WEST SUSSEX COUNTY COUNCIL CONSULTATION

TO:	Arun District Council FAO:Ms M Tomalova
FROM:	WSCC - Highways Authority
DATE:	20 June 2022
LOCATION:	7 Ambleside Close Bognor Regis PO22 8NG
SUBJECT:	FP/84/22/PL Erection of 1 No three-bed detached dwelling (resubmission of FP/86/21/PL). This site is in CIL Zone 4 and is CIL Liable as a new dwelling.
DATE OF SITE VISIT:	n/a
RECOMMENDATION:	Advice
S106 CONTRIBUTION TOTAL:	n/a

PROPOSED SITE PLAN
SCALE: 1:100 @ A1

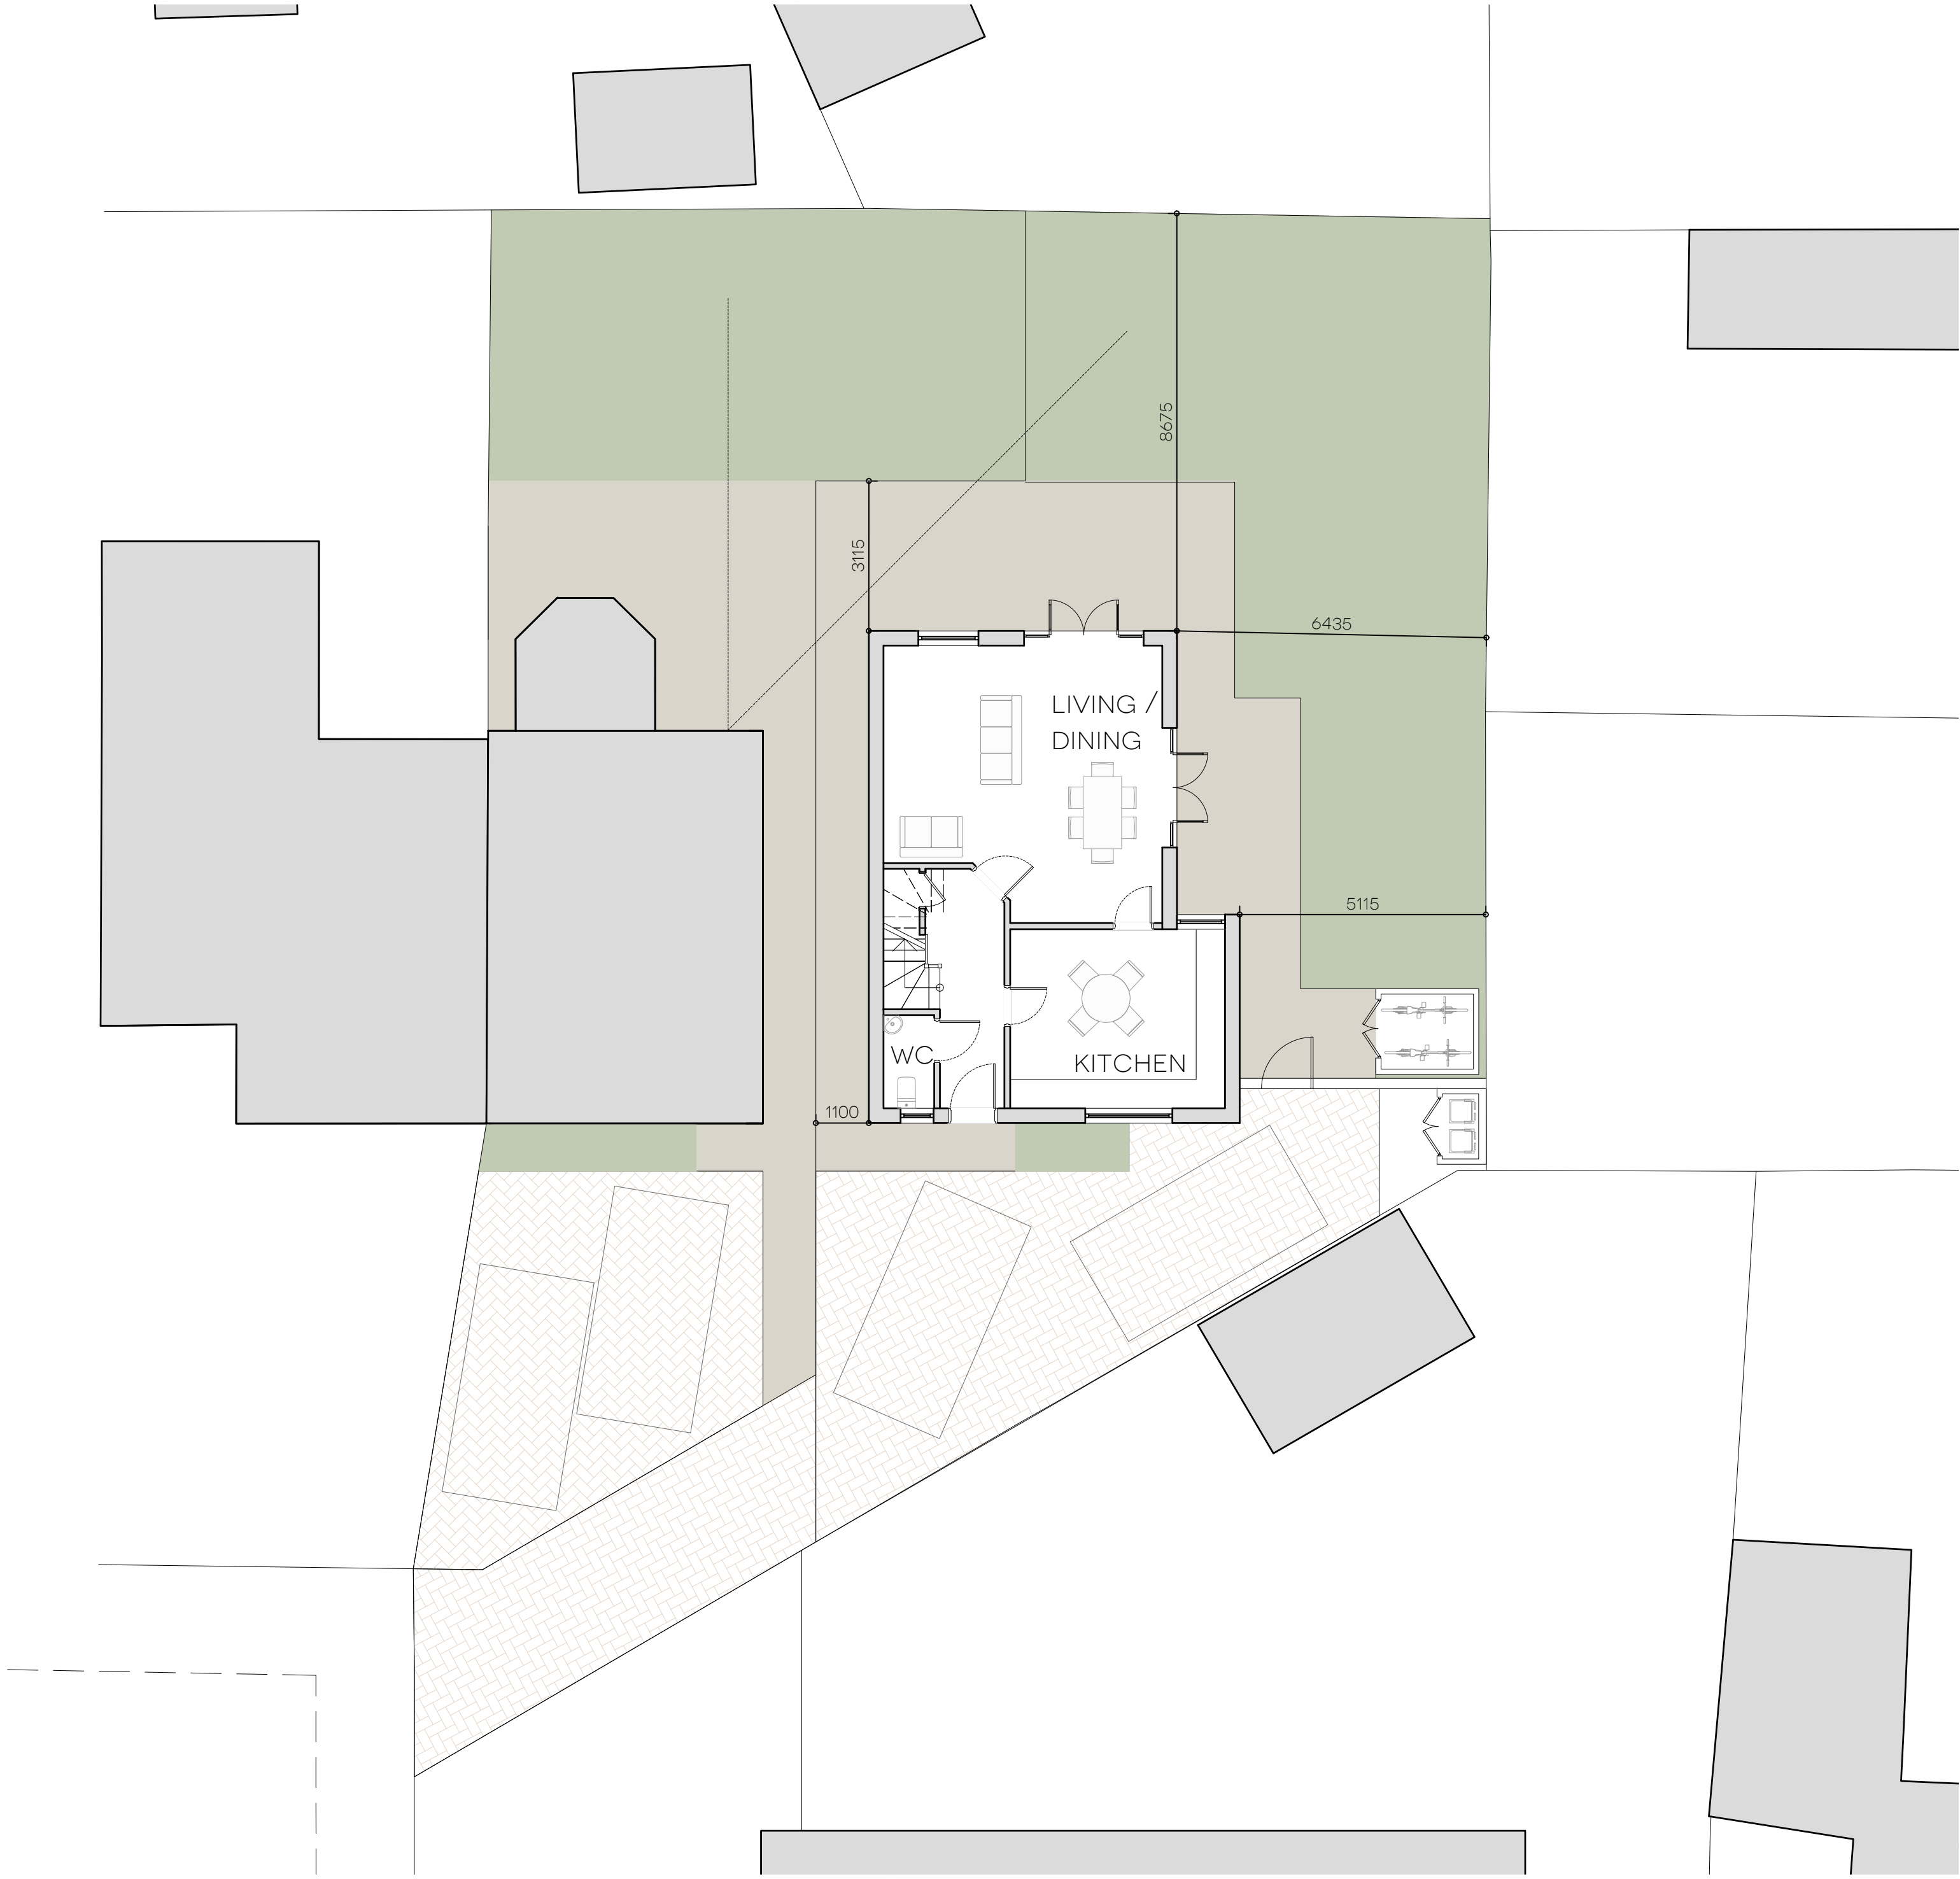
The proposal will utilise the existing access onto Ambleside Close, providing a shared driveway and two parking areas for both the existing and proposed dwellings. No visibility issues with the access arrangement are anticipated.

The vehicle parking is proposed to be in the same location as the previous application (FP/86/21/PL). Swept path tracking has been provided for the previous application demonstrating that vehicles can enter and exit each space in forward and reverse gears. As such no highways concerns over the proposed parking arrangements would be raised.

The LHA would also not raise a highway concern to the lack of on-site turning space on site, given the nature of the no-through residential road and neighbouring properties operating similar arrangements.

The site is sustainably located within walking distance of local shops and amenities and primary and secondary schools. Secure and covered cycle storage is proposed within the rear garden of the proposed dwelling to encourage sustainable transport methods.

No part of the development shall be first occupied until the car parking has been constructed in accordance with the approved site plan. These spaces shall thereafter be retained at all times for their designated purpose.

No part of the development shall be first occupied until covered and secure cycle parking spaces have been provided in accordance with the approved site plan.
